THE RESERVE AT CORRAL BLUFFS SUBDIVISION FILING NO. 3 Construction Drawings El Paso County, Colorado

SF-20-007

TITLE SHEET

SHEET: C1

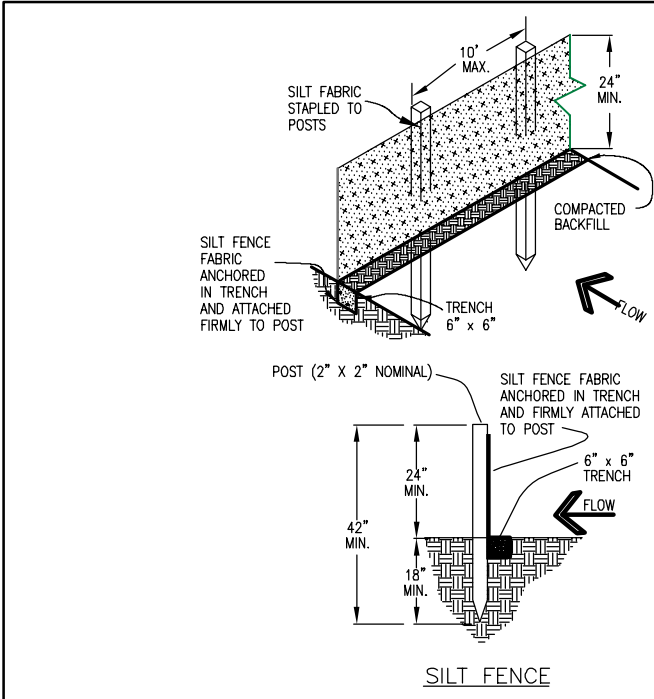
Add a note about the existing vegetation

Add a note that no dedicated asphalt or concrete batch plants are planned on-site.

Add a note stating that contractor shall update and annotate the SWMP Maps to show the location of the construction trailer, stabilized staging area, CWA, and other items as these locations are determined on site.

Seeding must be completed within 21 days after grading is complete

include erosion control blankets

provide temporary sediment basin details
 Provide erosion control blanket details

provide the date and preparer of the soils report
